DOC16/597377  
EF16/3389

**Mayfield Resource Recovery Facility SSD 7698 - 1a McIntosh Drive, Mayfield West, Newcastle**

The EPA has reviewed the *Environmental Impact Statement, Mayfield West Recycling Facility at 1a McIntosh Street, Mayfield West* ("the EIS") prepared for Benedict Recycling Pty Ltd dated October 2016 and provides the following comments.

The EPA has reviewed the Air Quality Impact Assessment (AQIA) titled, *Mayfield West Recycling Facility – Production Increase. Air Quality and Greenhouse Gas Assessment* (Ramboll Environ, September 2016) and is of the opinion that it has been prepared generally in accordance with the *Approved Methods for the Modelling and Assessment of Air Pollutants in NSW (Approved Methods)*. However, the EPA has identified some issues with the AQIA, detailed below, which require addressing via the provision of a revised assessment and prior to issuing recommended conditions of approval.

Figure A3.2 Predicted Incremental Maximum 24-hour Average PM₁₀ Concentrations (µg/m³)

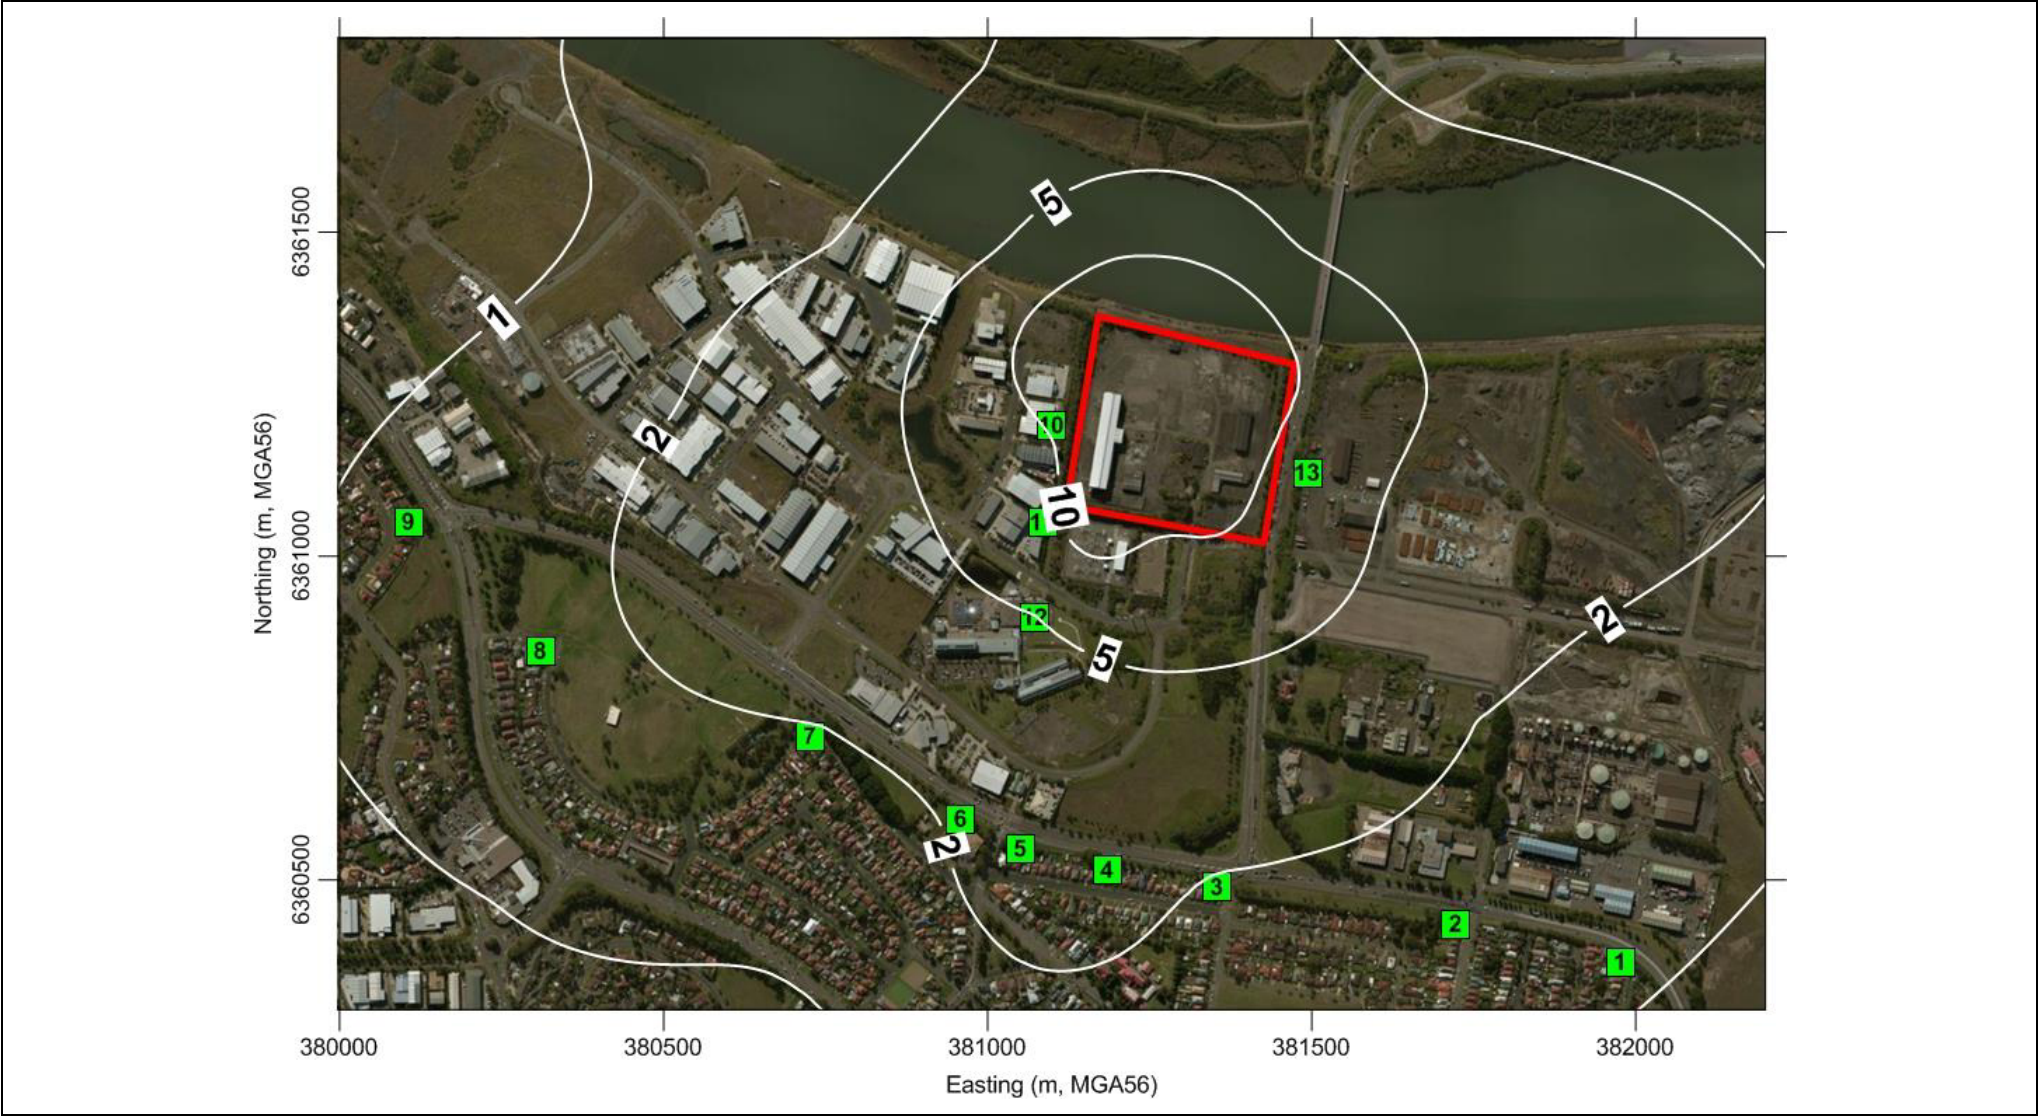
**4. The AQIA predicts one additional exceedence of 24 hour average PM<sub>10</sub> concentration per year.**

The modelling predicts one additional day of exceedences in PM<sub>10</sub> 24 hour average concentration per year. However, the AQIA concludes that the proposed expansion is unlikely to result in exceedences in the air quality impact assessment criteria, due to the very conservative assumption that all material received at the facility is processed.

Conclusions should not be inconsistent with modelling results. If the assumptions are considered too conservative then they should be revised, with justification, and modelling redone.

Processing data of the current operations could be used to give a more realistic ratio of materials received to materials processed. If remodelling (including maximum operating conditions discussed in 3 above) still indicates exceedences, then further mitigation measures need to be considered, and the AQIA revised accordingly.

***The modelling should be revised to include more realistic (justifiable) assumptions. If exceedences are still predicted, then, in accordance with Section 11.2.3 of the Approved Methods for the Modelling and Assessment of Air Pollutants in New South Wales, the proponent must revise the AQIA to include the application of effective mitigation measures or emission controls.***

Figure A3.7 Predicted Incremental 99th Percentile 1-second Average Odour Concentrations (OU)

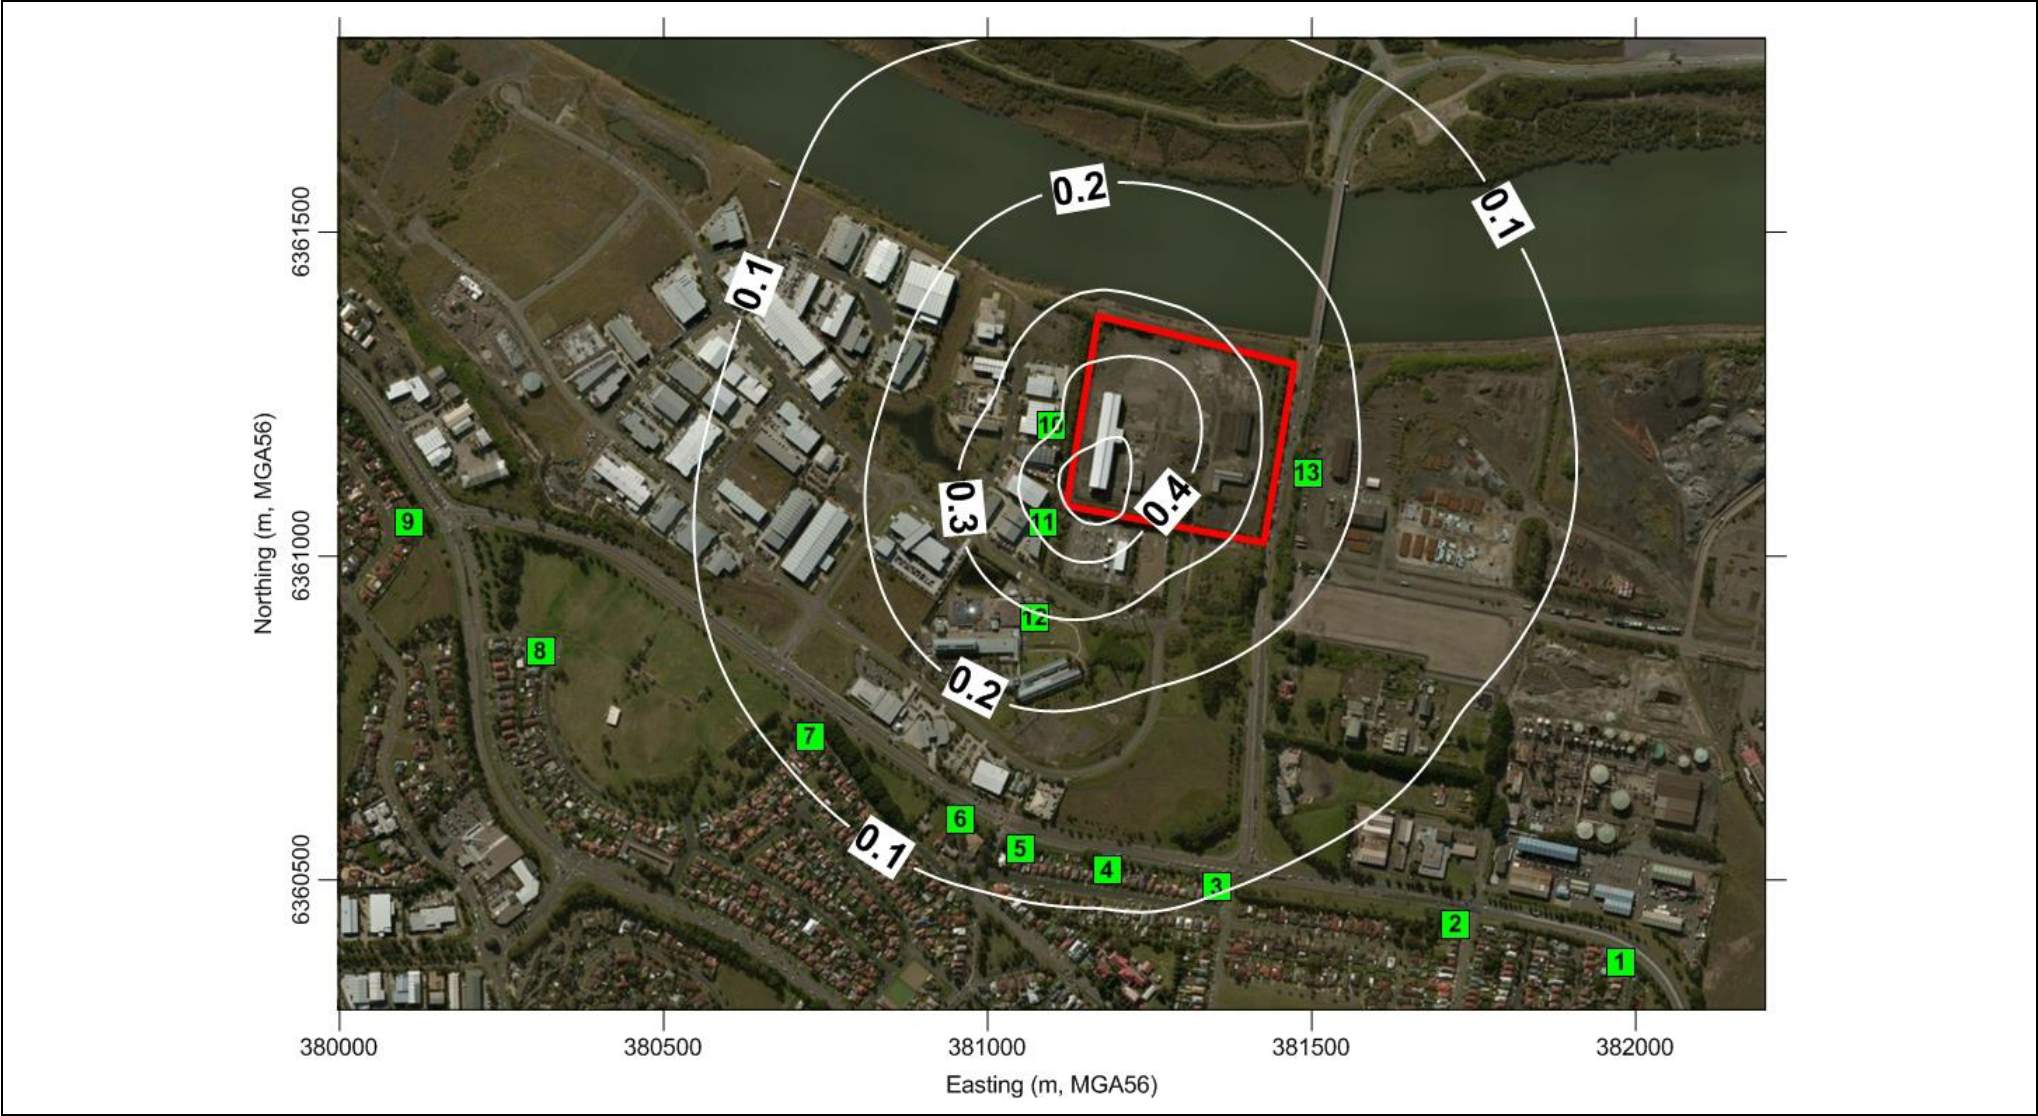
**2. It is unclear whether the glass stockpiles can be a significant source of odour.**

Glass is crushed at the site and stockpiled outside. It is unclear from where the glass is sourced. If glass has been sourced from kerbside collections, then odour emissions from crushed glass stockpiles can be significant. Currently the AQIA assumes that the only odour source at the site is greenwaste.

***The AQIA should specify from where the glass is sourced. If the glass is sourced from kerbside collections, then the stockpiles of crushed glass should be considered as a source of odour, and the AQIA revised.***
